Revision E - Section 75W Amendments.
1 Four spaces have been converted to two disabled spaces to accommodate increase in total adaptable apartments numbers (additional 2, from 59 to 61)

Site 3
Sydney Olympic Park
Plan
Basement 001

Revision E - Section 75W Amendments.

**Site 3
Sydney Olympic Park
Plan
Level 23**

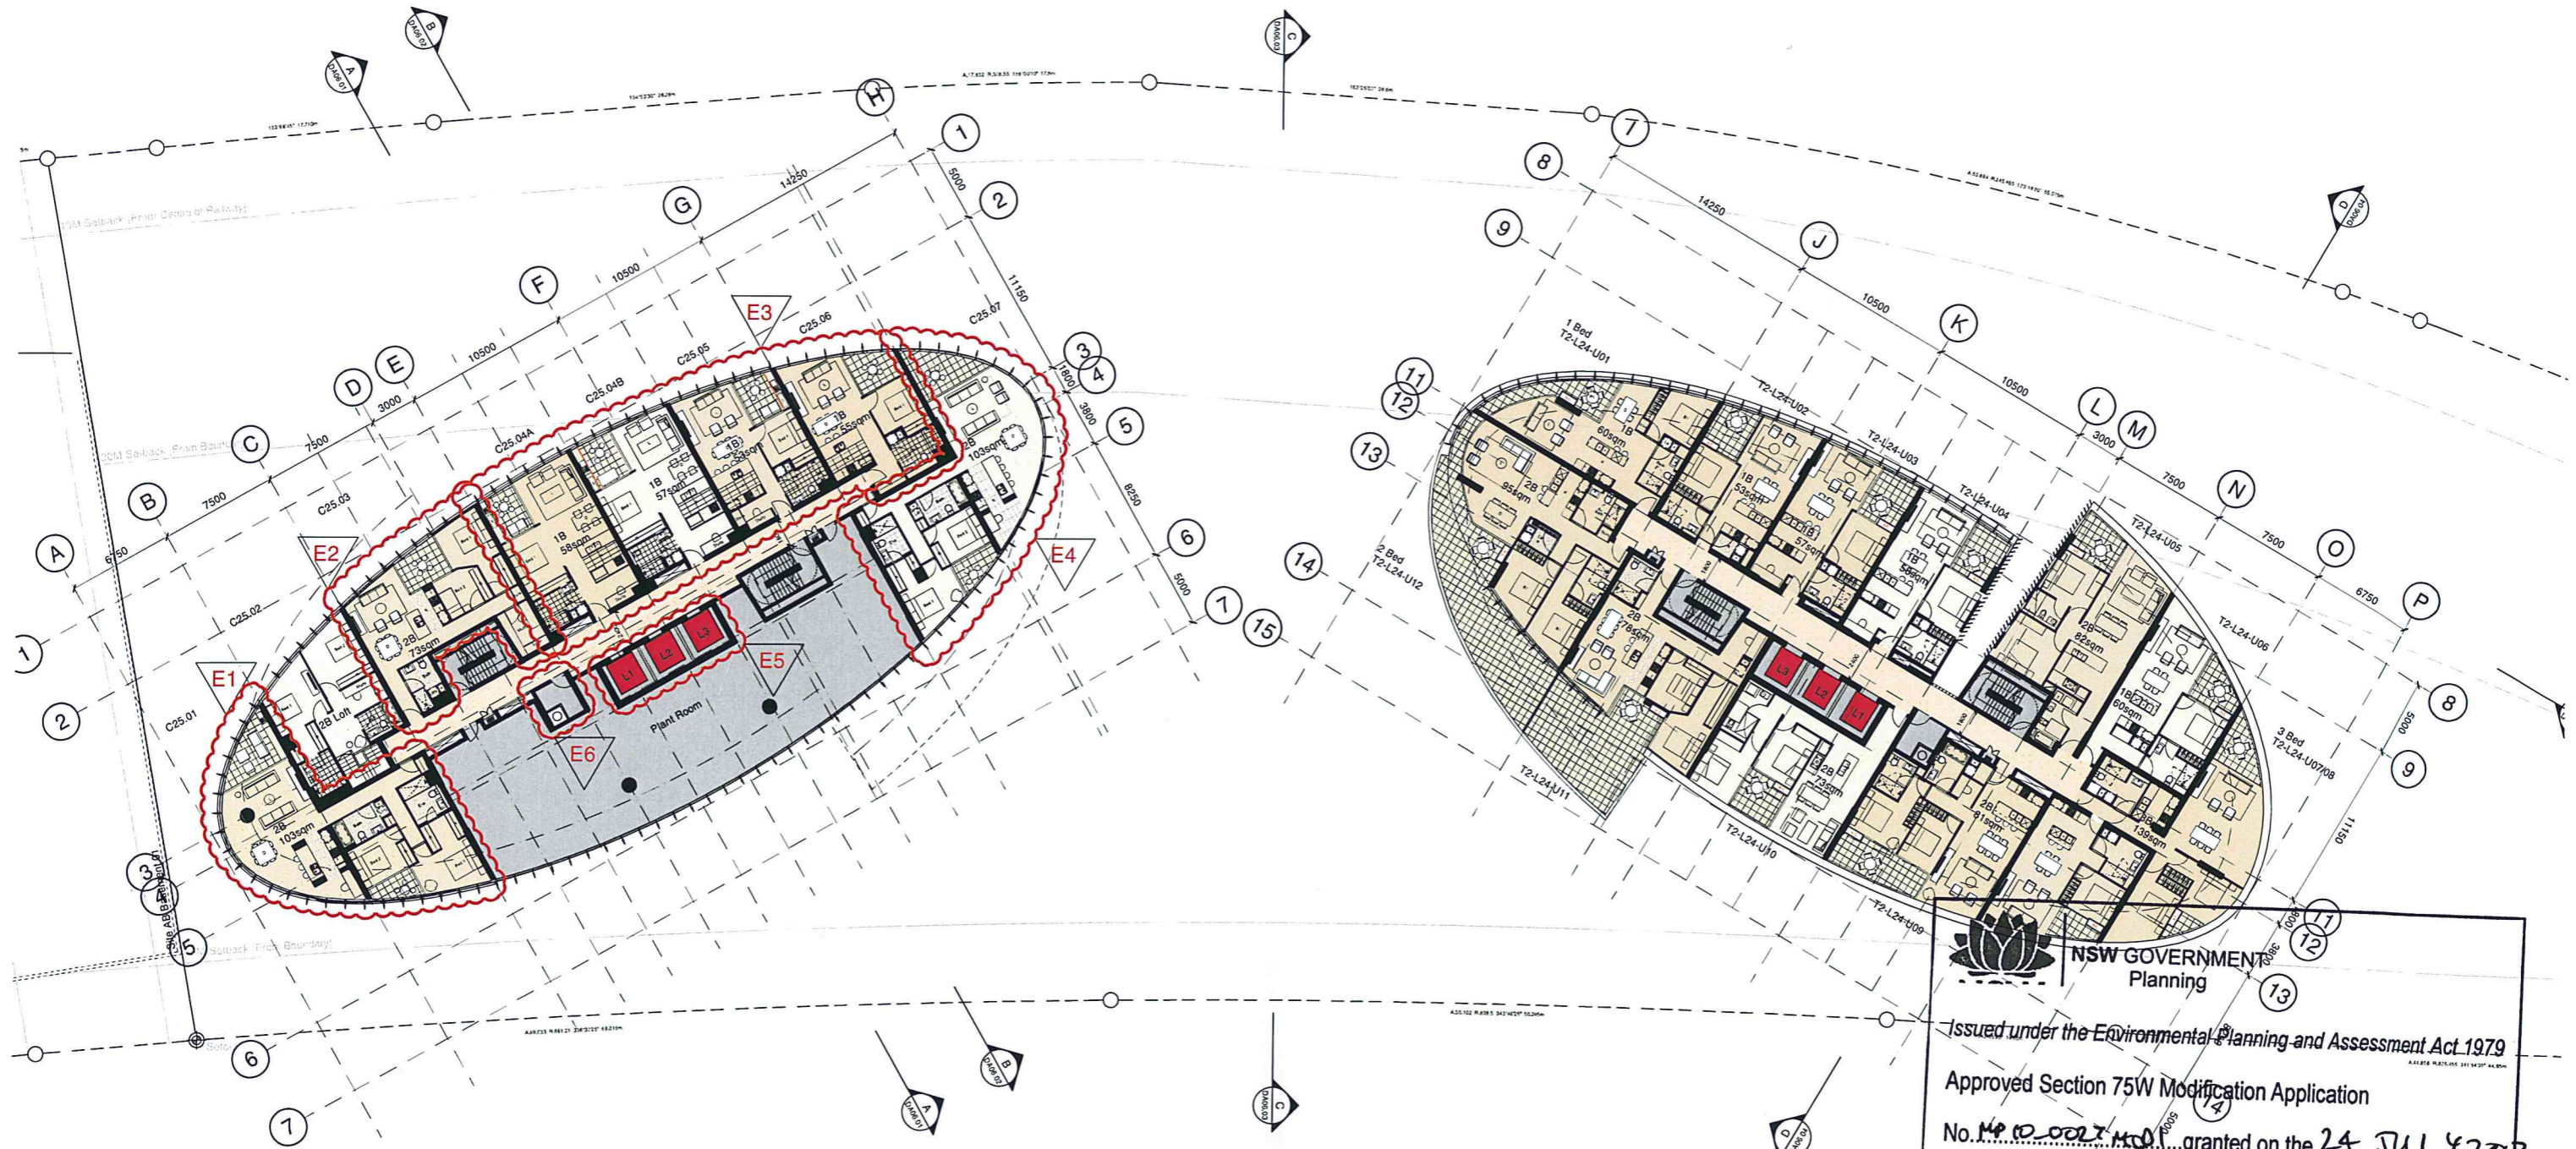
- Revision E - Section 75W Amendments.
- One 3-Bed Loft (C25.01) has been modified to one 2-Bed single storey apartment (C24.01).
 - One 3-Bed Loft (C25.03) has been modified to one 2-Bed single storey apartment (C24.03).
 - One 2-Bed Loft and two 4-Bed Lofts (C25.04, C25.05 & C25.06) have been modified to four 1-Bed single storey apartments (C24.04A, C24.04B, C24.05 & C24.06), including two units allocated as adaptable units.
 - One 3-Bed Loft (C25.07) has been modified to one 2-Bed single storey apartment (C24.07).
 - Change of apartment mix from one 1-Bed and one 3-Bed (C25.09 & C25.10) to two 2-Bed (C24.09 & C24.10).

**Site 3
 Sydney Olympic Park
 Plan
 Level 24**

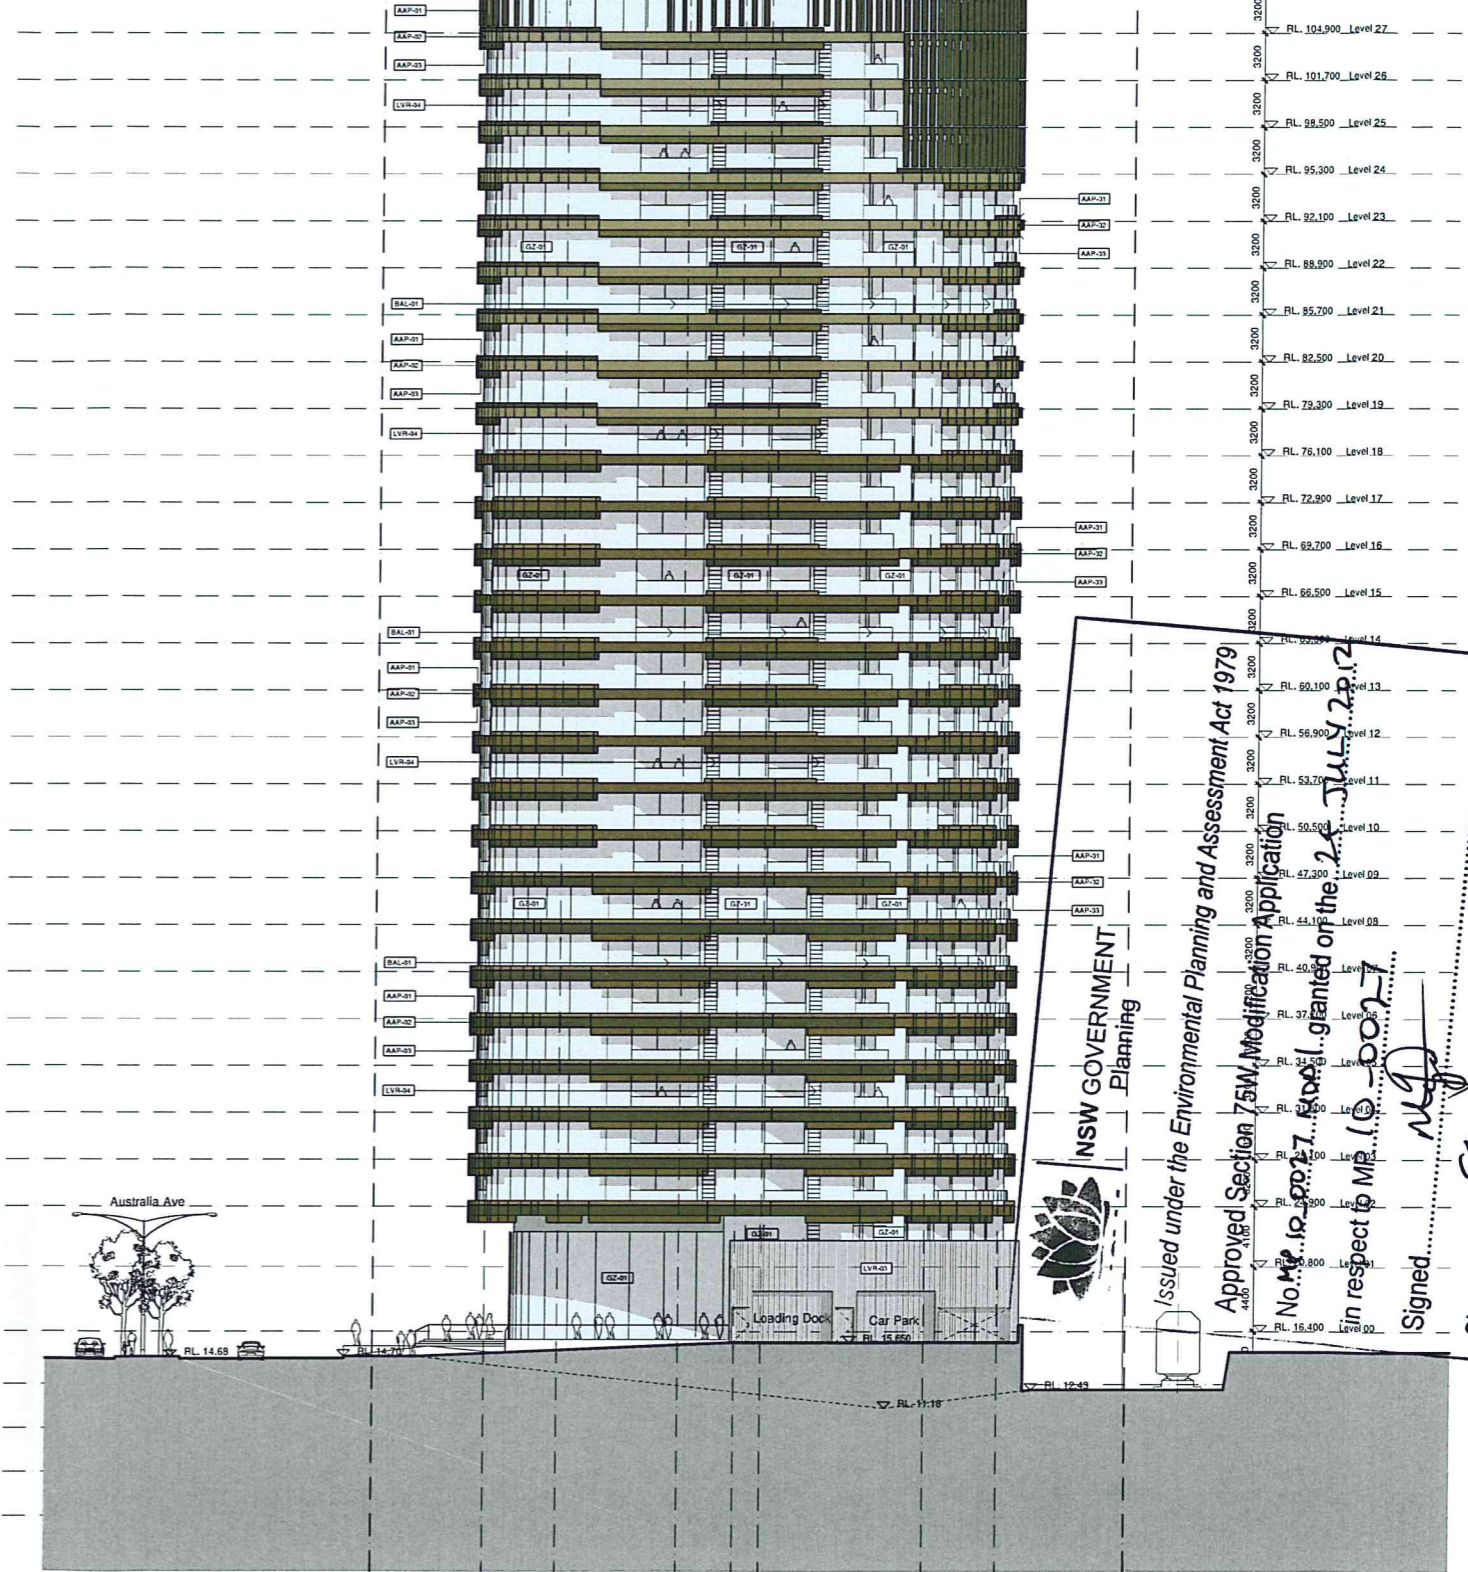
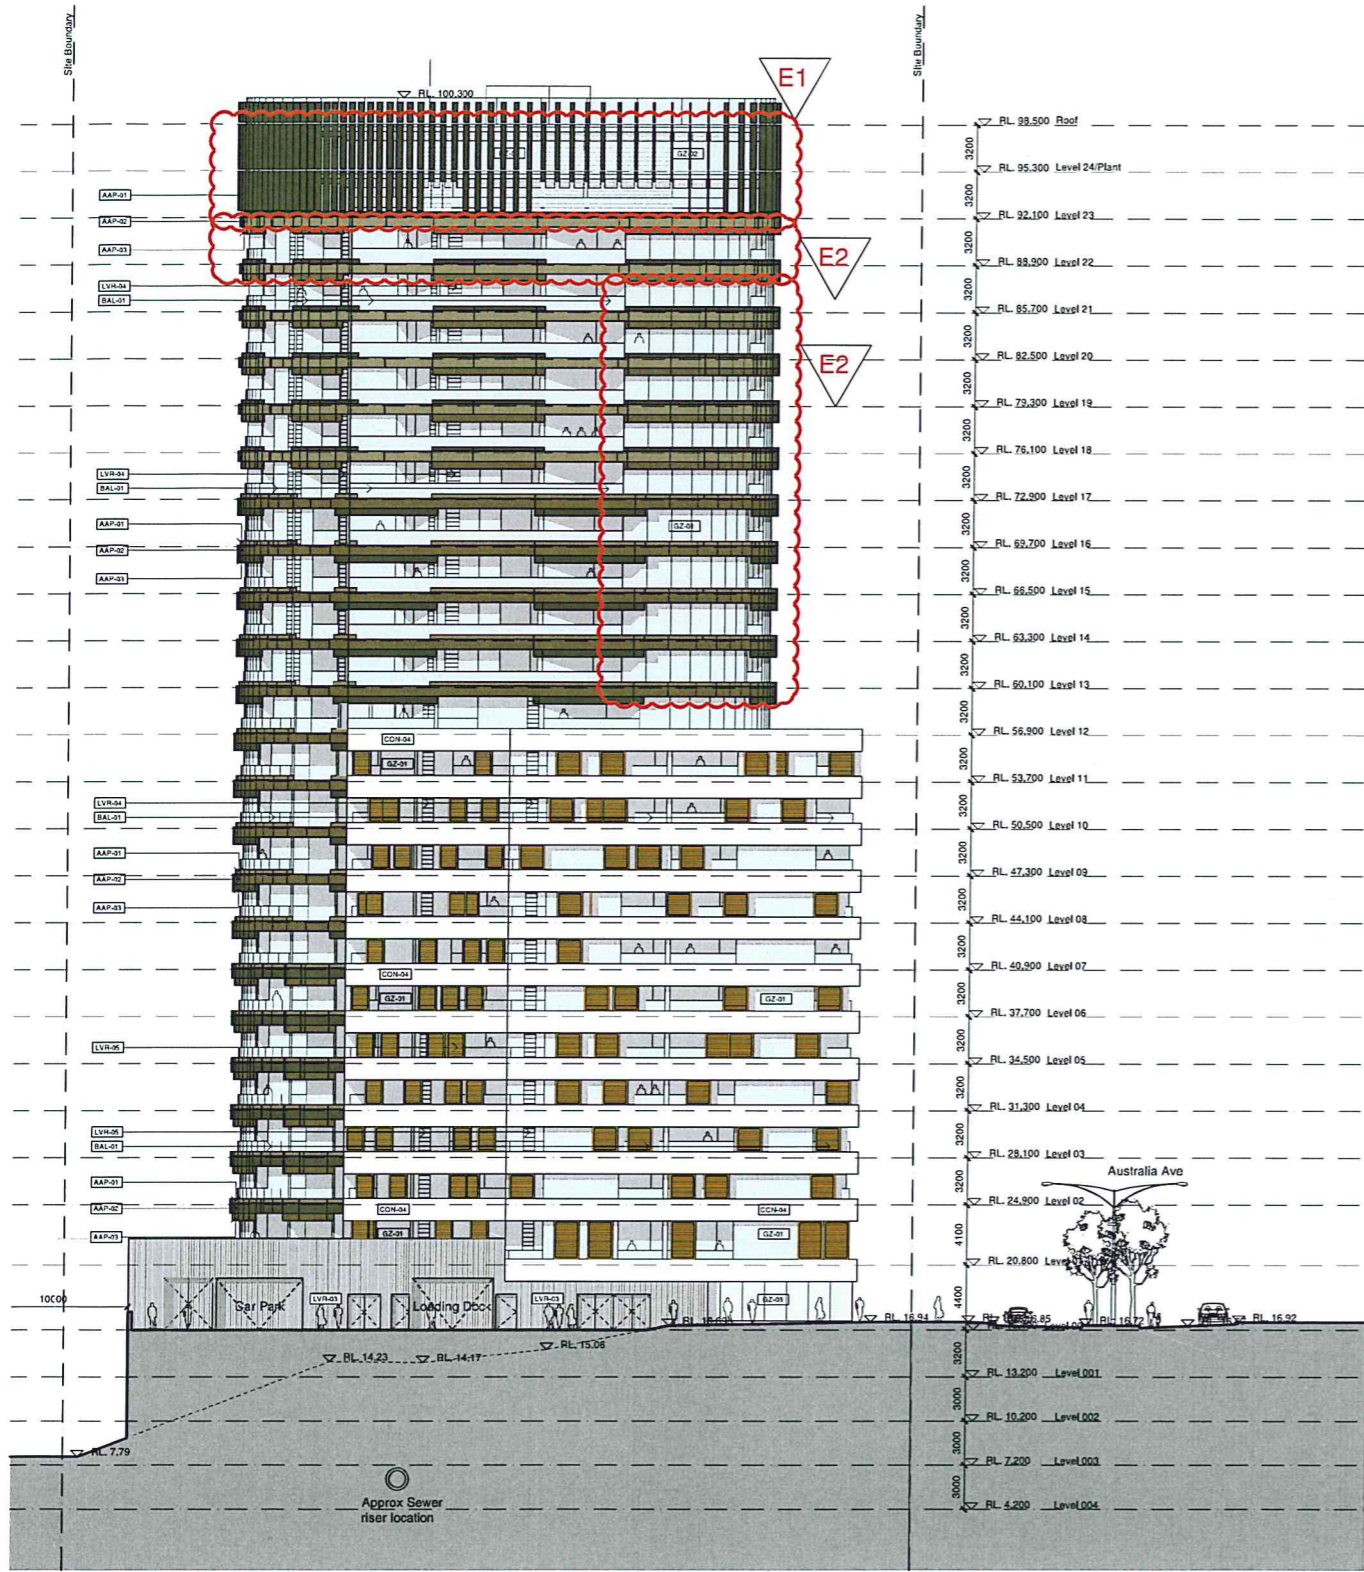
- Revision E - Section 75W Amendments.
- One 3-Bed Loft (C25.01) has been modified to one 2-Bed single storey apartment (C25.01).
 - One 3-Bed Loft (C25.03) has been modified to one 2-Bed single storey apartment (C25.03).
 - One 2-Bed Loft and two 4-Bed Lofts (C25.04, C25.05 & C25.06) have been modified to four 1-Bed single storey apartments (C25.04A, C25.04B, C25.05 & C25.06), including two units allocated as adaptable units.
 - One 3-Bed Loft (C25.07) has been modified to one 2-Bed single storey apartment (C25.07).
 - Lift access has been extended to serve Level 24 apartments.
 - Garage room has been added to serve Level 24 apartments.

Drawing No.: DA05.01[E] [Revision]

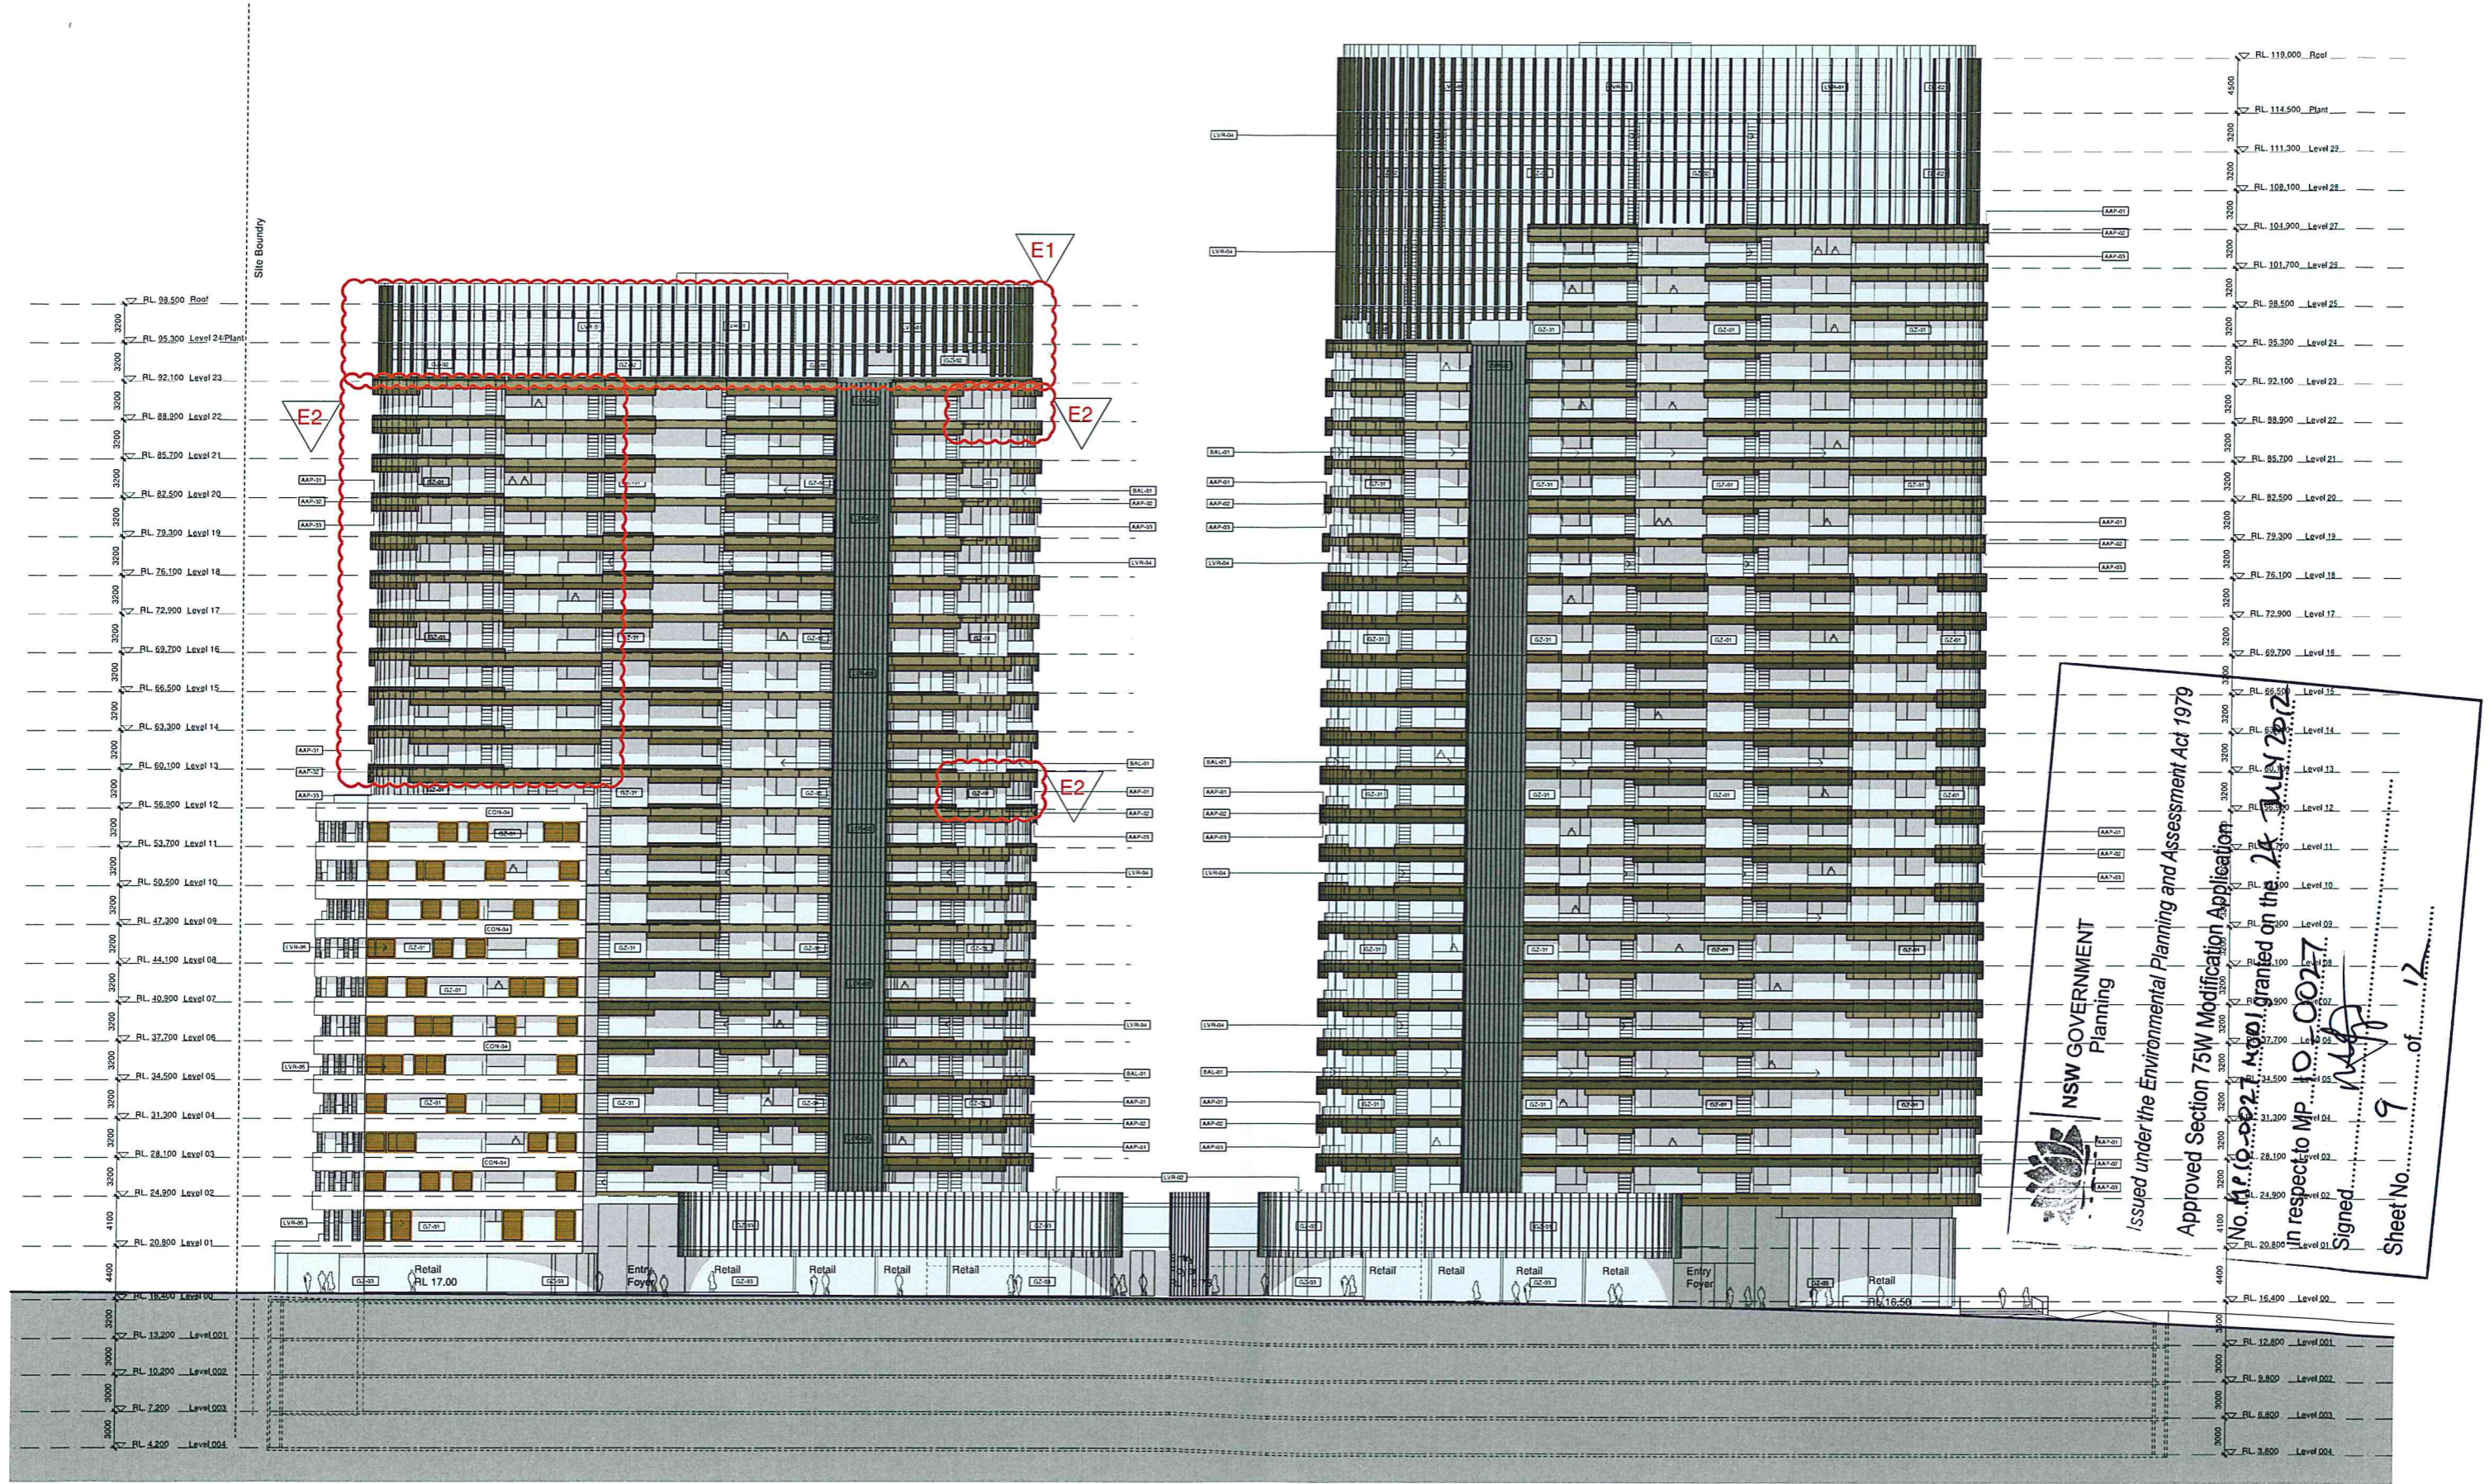
- Loft apartments modified to single storey apartments on Level 23 & 24. Elevation amended to match current plans.
- Elevation amended to match current plans.
